Appendix 1 Detailed Response to Issues Raised

Table 1. Detailed Response to Issues Raised in Submissions

1. Issues Raised in Submissions from the City of Sydney

WINTER SOLSTICE 9AM ENVELOPE SHADOW

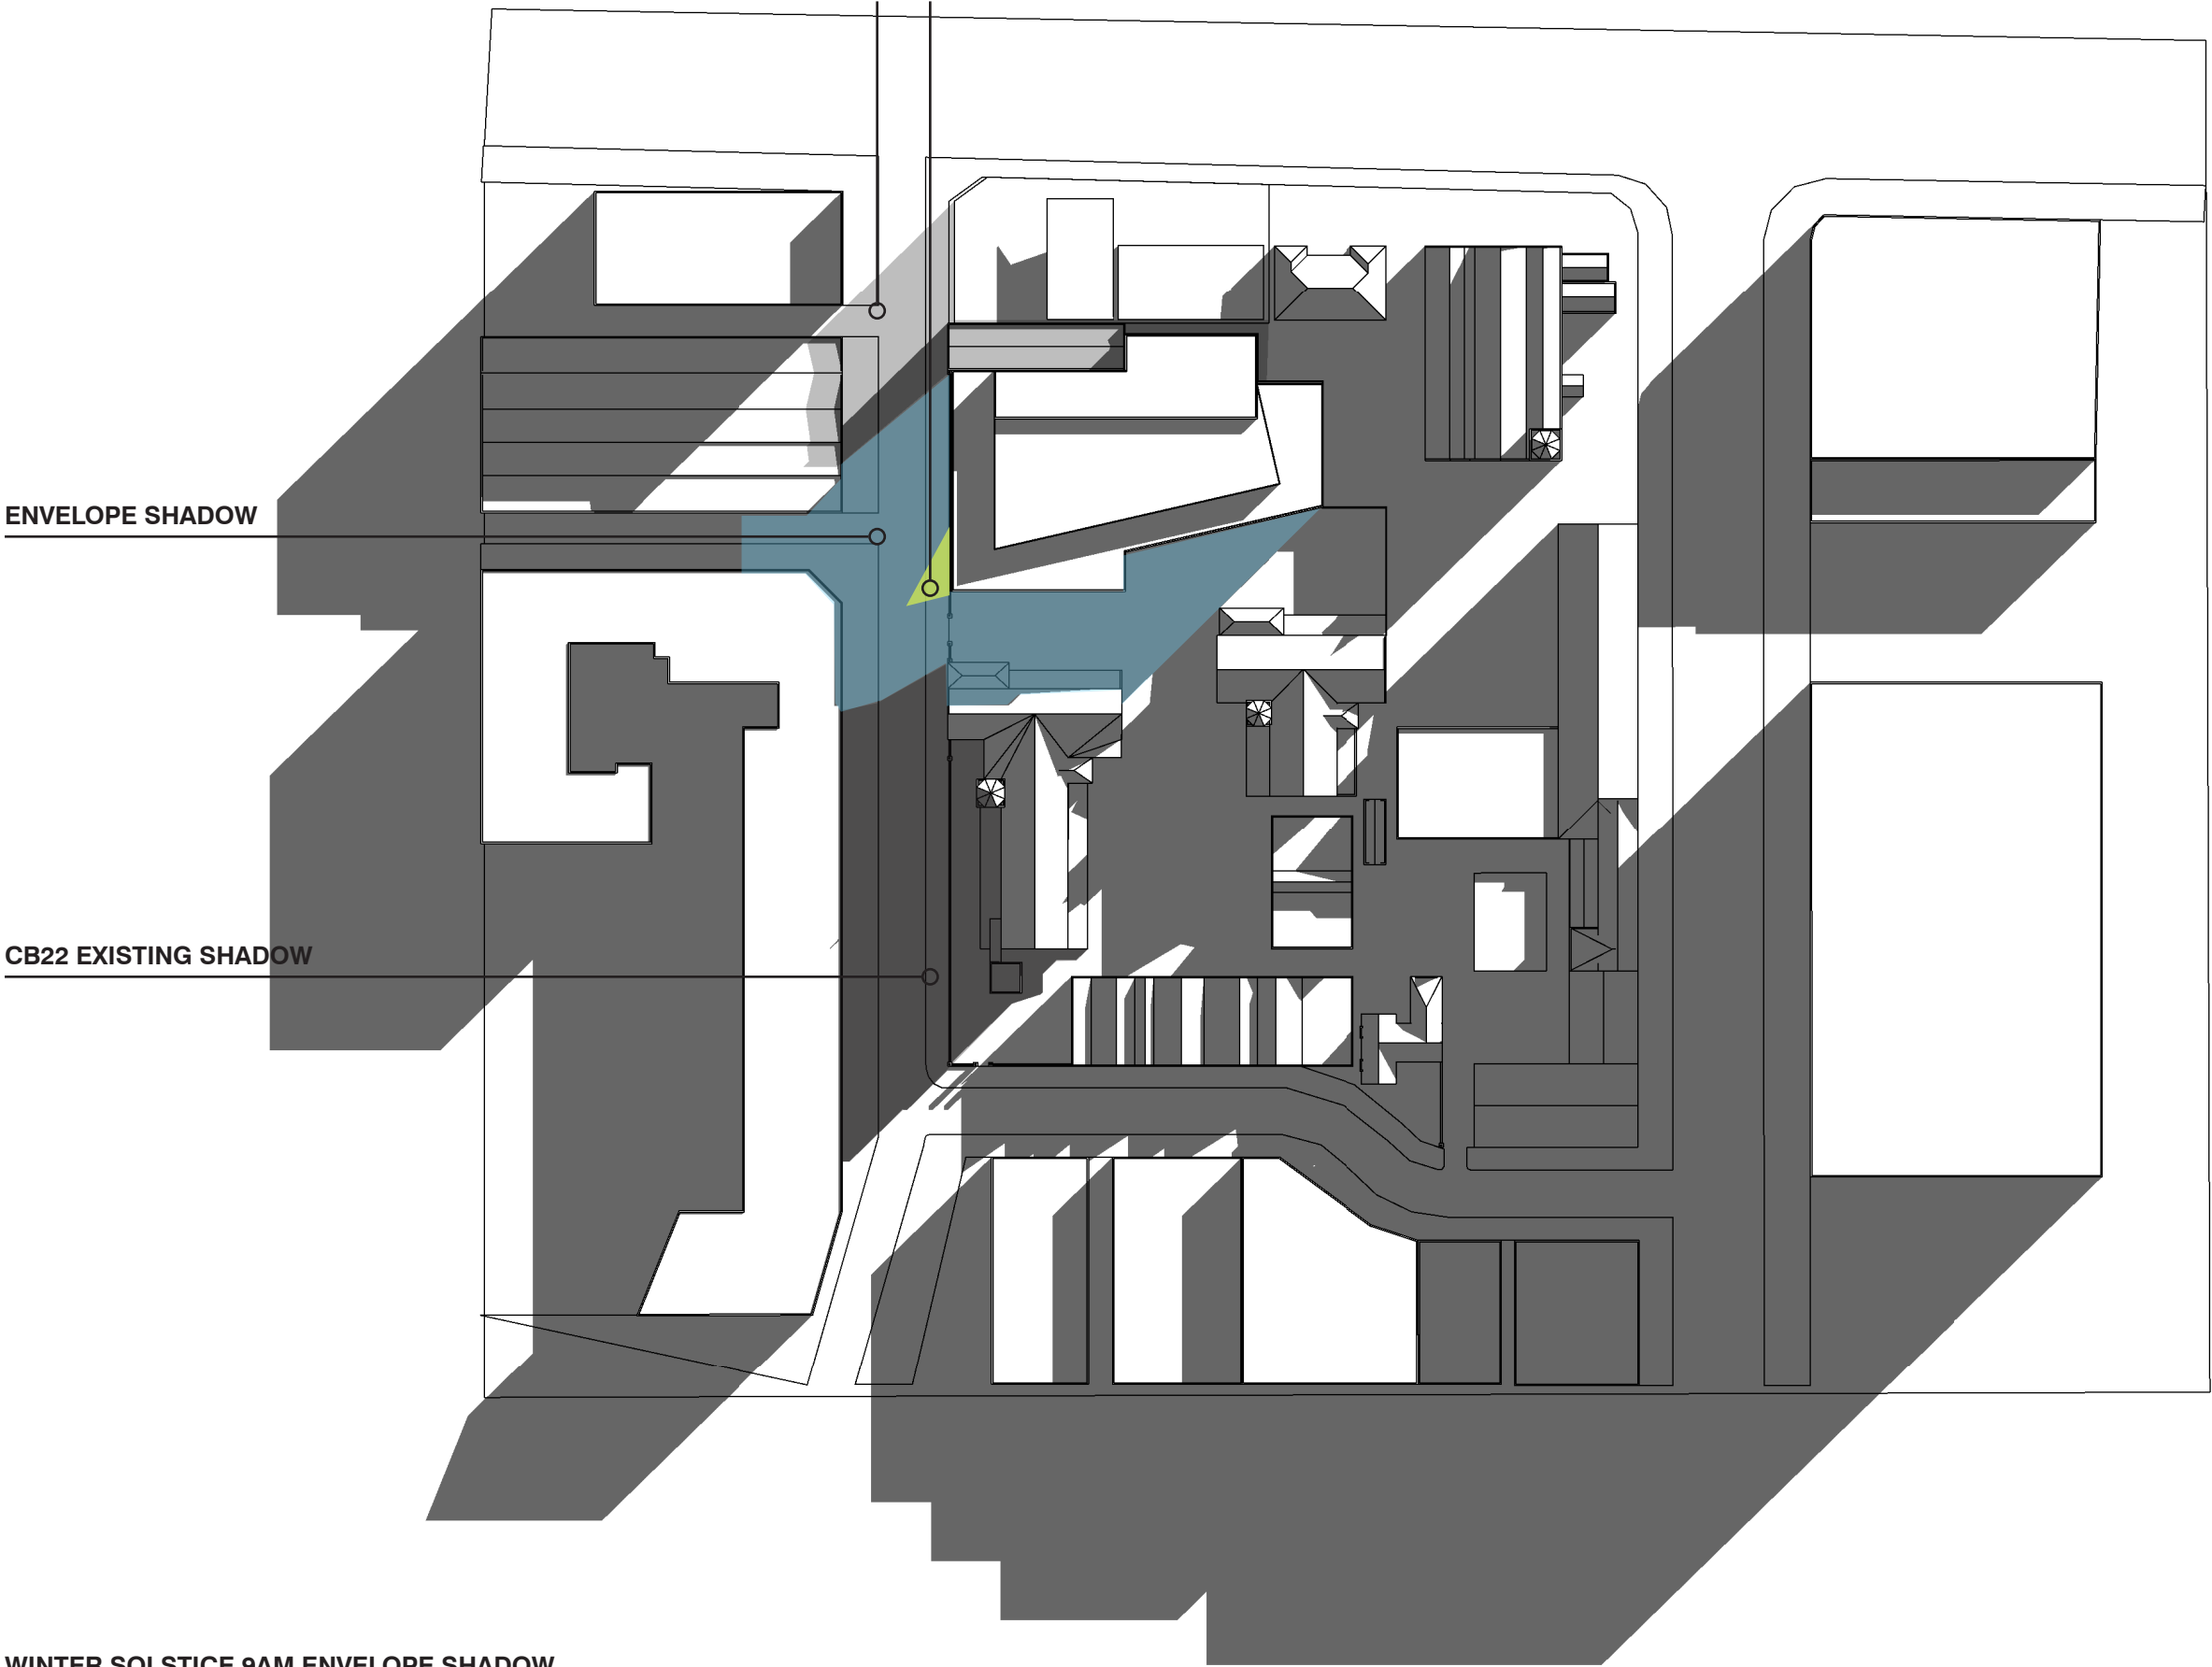
7. Issues Raised in Submissions from the University of Notre Dame Australia, submission prepared by TKD Architects	
Issue	Response
Non compliance with local planning codes	Clause 4.6 variations for the non-compliances with floor space and height have been included in the application
Overshadowing: The proposed envelope would result in some overshadowing of the UNDA St Benedict’s Campus particularly the St Benedict’s courtyard.	UTS has revised the proposed envelope to reduce its height in key areas and overall form with resulting reduced impacts to surrounding areas. This is discussed in the RTS report at Section 1.2. The shadows to the UNDA courtyard have been reduced as a result of these changes. These are shown on the revised shadow diagrams in the RTS report at Section 2.3.
Visual impact/bulk and scale: Visual impact from bulk and scale within the courtyard; a wall within close proximity to the St Benedict’s boundary is likely to be a solid wall without any openings adding	UTS has revised the proposed envelope to reduce its height in key areas and overall form with resulting reduced impacts to surrounding areas. This is discussed in the RTS report at Section 1.2.

Drawing Title
UTS BLACKFRIARS CAMPUS CB23
A02 - PROPOSED BUILDING
ENVELOPE PLAN

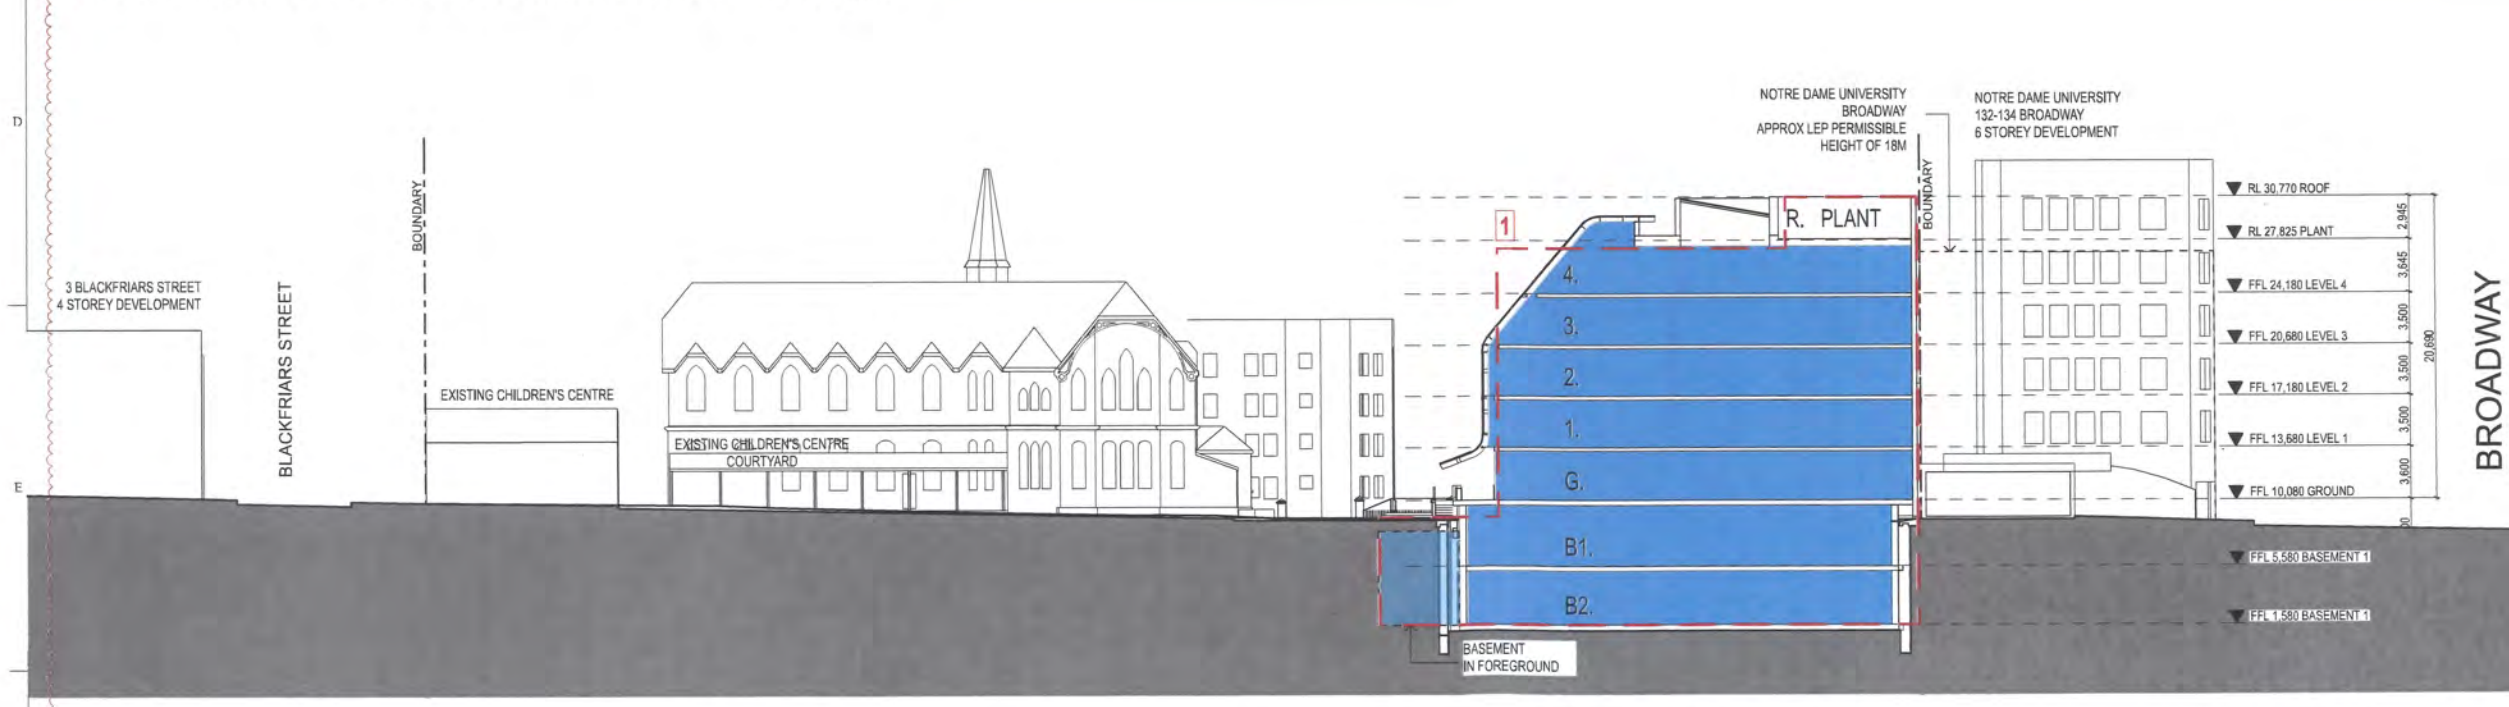
Building form. Council recommends that the building envelope should be modified so as to be parallel or perpendicular to the existing heritage buildings. Steps in the building envelope or future building footprint should relate to the existing courtyard typology and respect historic alignments. Council has also requested that the minimum floor-to-floor heights be 3.6m for the ground floor and 3.3m for the floors above in accordance with the Sydney Development Control Plan 2012	UTS has revised the proposed envelope to reduce its height in key areas and overall form with resulting reduced impacts to surrounding areas. This is discussed in the RTS report at Part 1. These changes have included modification of the envelope to be orthogonal to the existing heritage buildings. UTS considers that the comments by Council regarding the non-orthogonal envelope may indicate Council has not fully understood the difference between the form set by an envelope and the eventual design of a building that fits within that envelope. As state significant development, Sydney Development Control Plan 2012 does not apply to the proposal. Notwithstanding, the revised envelope provides for floor-to-floor heights of 3.6m for the ground floor and 3.5m for the floors above.
